STATE OF NORTH CAROLINA
DEPARTMENT OF TRANSPORTATION

Addendum No. 1

RE: Contract # C204566
WBS # 2021CPT.04.06.10511, etc.

1 SECTION OF US-301, 1 SECTION OF NC-210, AND 22
SECTIONS OF SECONDARY ROADS.

TYPICAL SECTION NO. 4

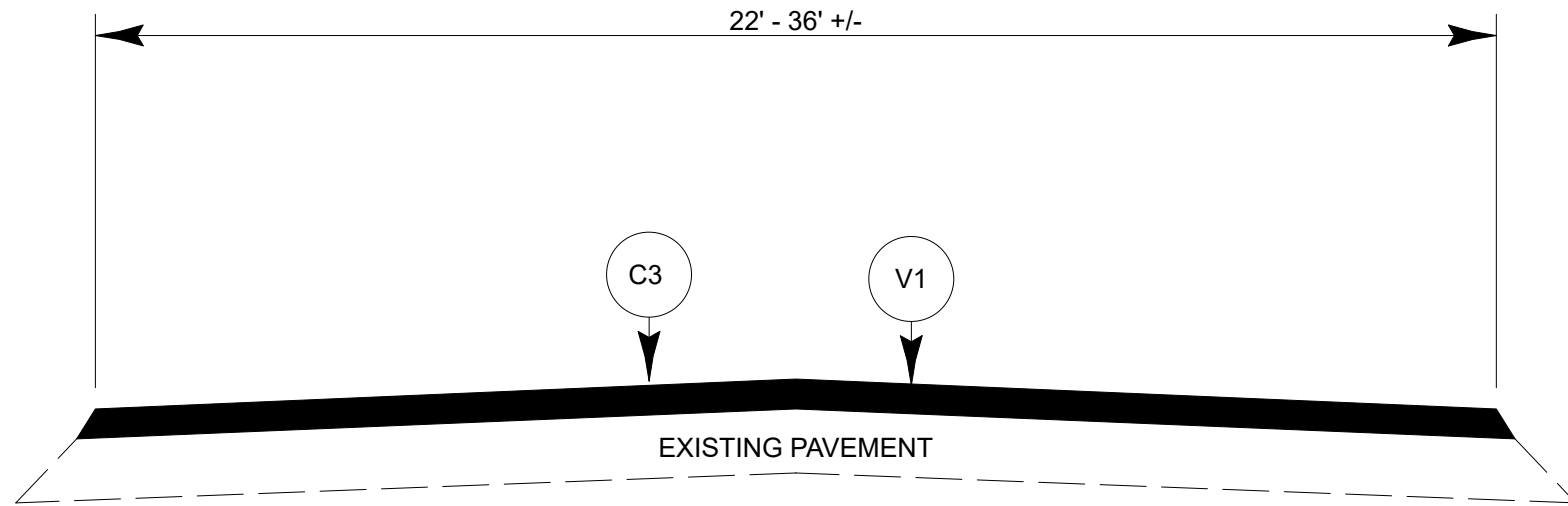
Sheet No.	Revision
7	Typical Section #4 was added
8	Typical Section #6 was added
12	Typical section references for Maps 1, 2, & 20 were revised
